222 Baseline Road

Cover Letter – Public Consultation Strategy and Urban Design Brief

Urban Design Brief

Schematic Elevations

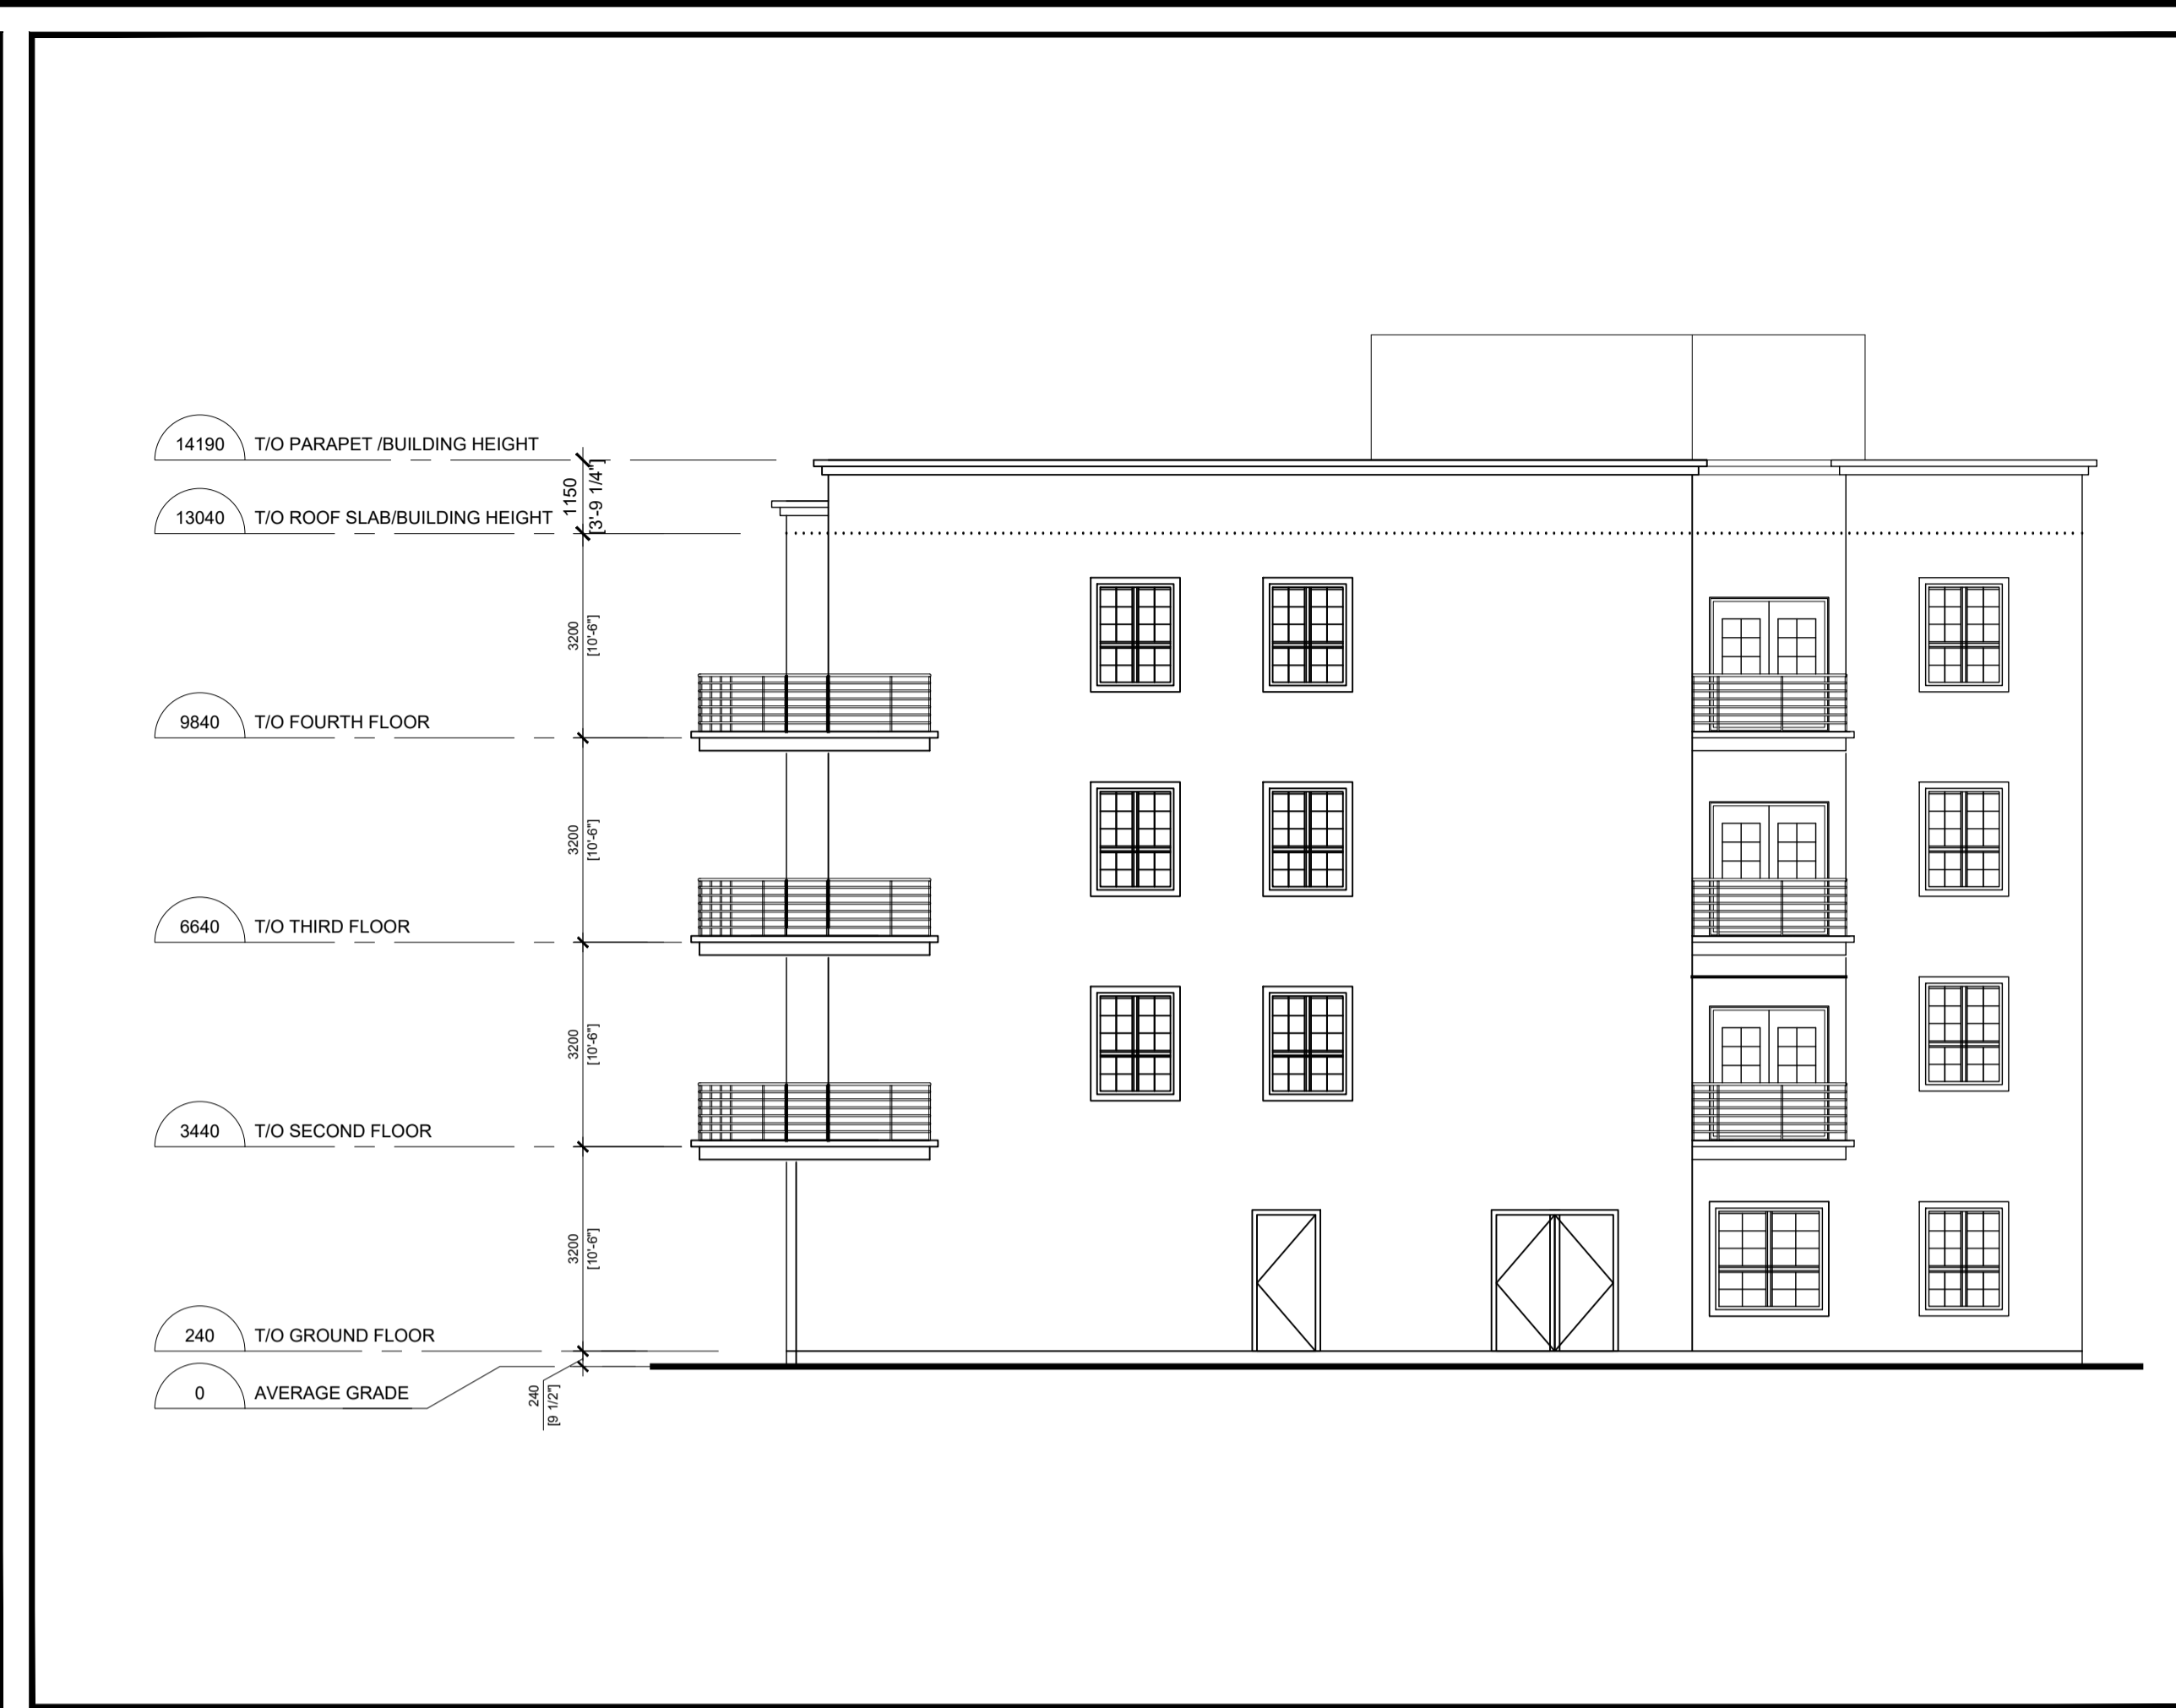
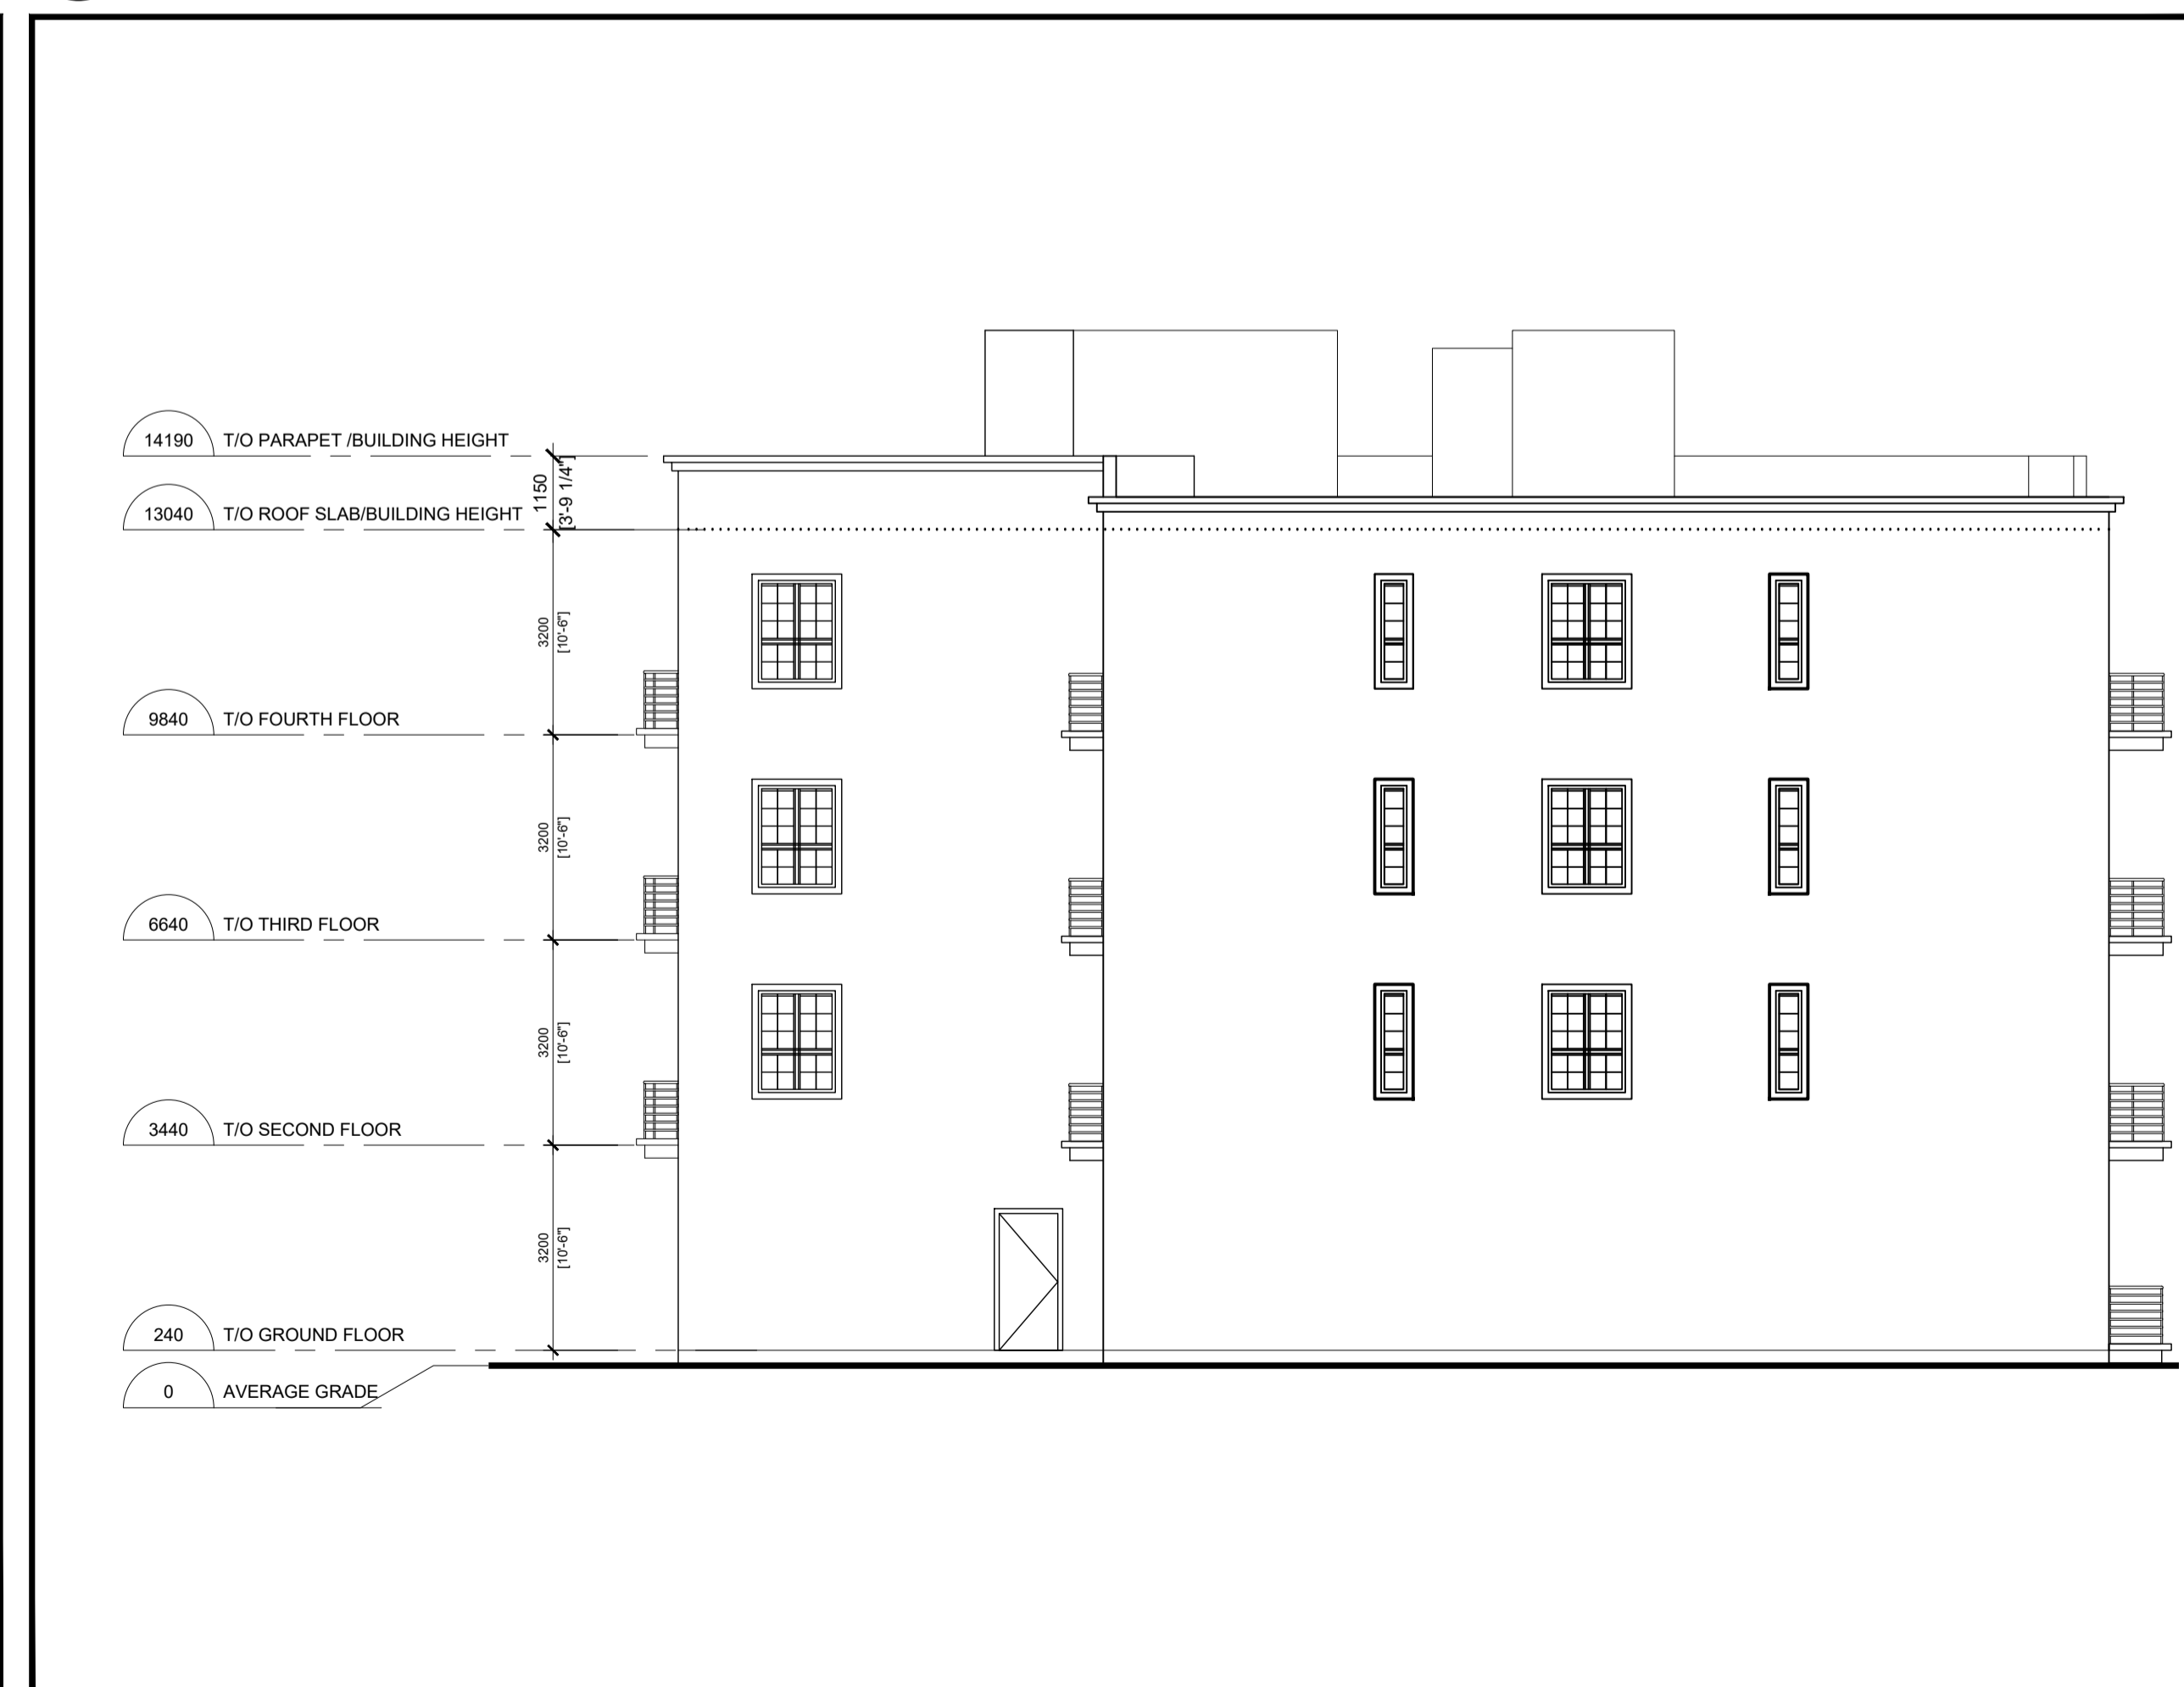
8) Materiality: As the first redevelopment project to the block and of such a change in scale we recommend the design attempt to 'fit' into the neighbourhood by employing similar materials found within the community. We recommend the use of corrugated metal be restricted to facades NOT facing any public right of ways.

Elevations and materials are currently under development; the recommendation regarding corrugated metal use will be taken into consideration.
